# CITY OF PORTLAND

# BUILDING PERMIT

Job ID: 2012-02-3327-ALTR

has permission to Build 24' x 25' detached garage

Arthur Ellis	
BRUCE R. BOWMAN, Inc. Professional Land Surveyor 48 Mill Road, Cumberland, Maine 02939	
Date: 8-9-93	Job: 213-20
Drawn By:	Scale: 1" = 30'

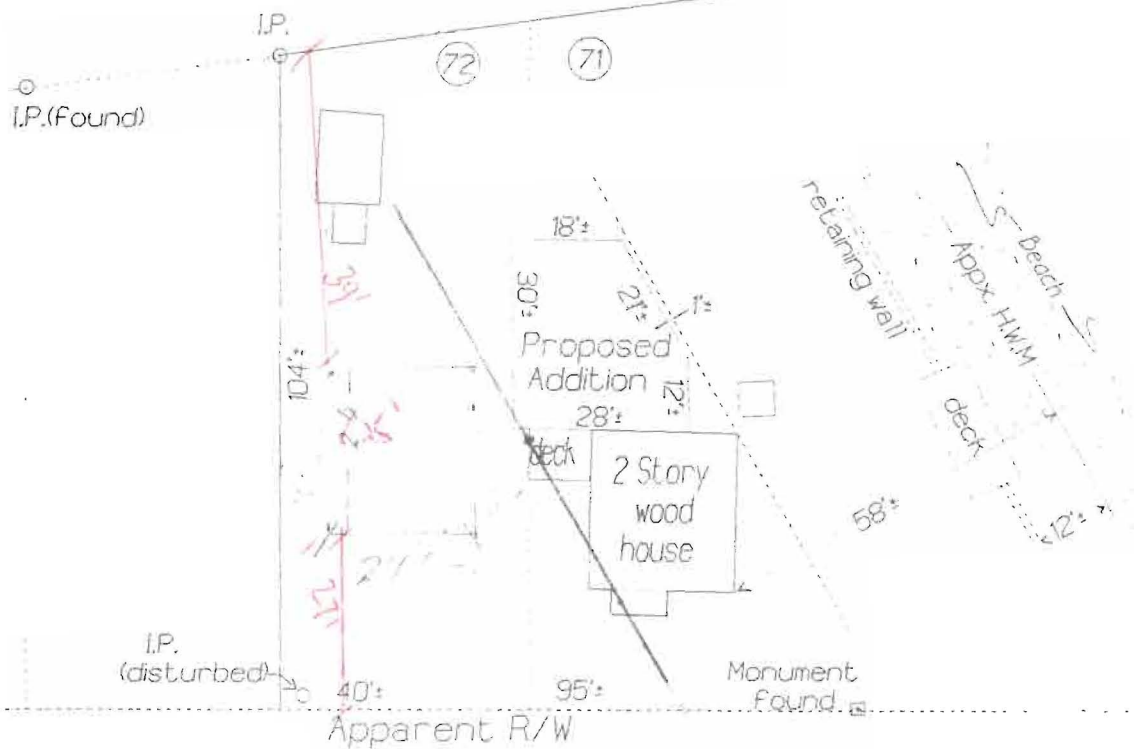
The garage must be reduced to 24' x 25' in order to be placed on a slab. Otherwise, there must be a 4'-0" frost wall.

3-16-12 - Neighbors came in to complain that small shed had been moved from where garage is being built. Shed must be minimum of 5' from side property line -

- Neighbors also complained that footprint of house shown on plot plan is not accurate - can the inspector confirm the <sup>footprint</sup> ~~size~~ of the house?

It has recently come to my attention that the 1993 survey was apparently manipulated to show buildings in different positions than the original 1993 survey. I was given google photos showing a shed in the position of where the garage is to be located. It was only moved "weeks ago" to the position shown on the 1993 survey. This office never received permits for the shed and its apparent new location. And it is known that you rebuilt your sea wall (with appropriate permits) in 2007.

Because of the all these recent activities, there is good reason to question your 1993 survey. At this time I am suspending your approval to build a garage. My inspection of the property today shows that no construction has begun for the garage. In order to re-activate your permit, I will need to see a revised, currently dated survey showing setbacks from the Highest Annual Tide (HAT) along with and including all the changes done to your property. I will also need a separate permit for the shed and its new location on your lot. All submittals will be subject to reviews and approvals.
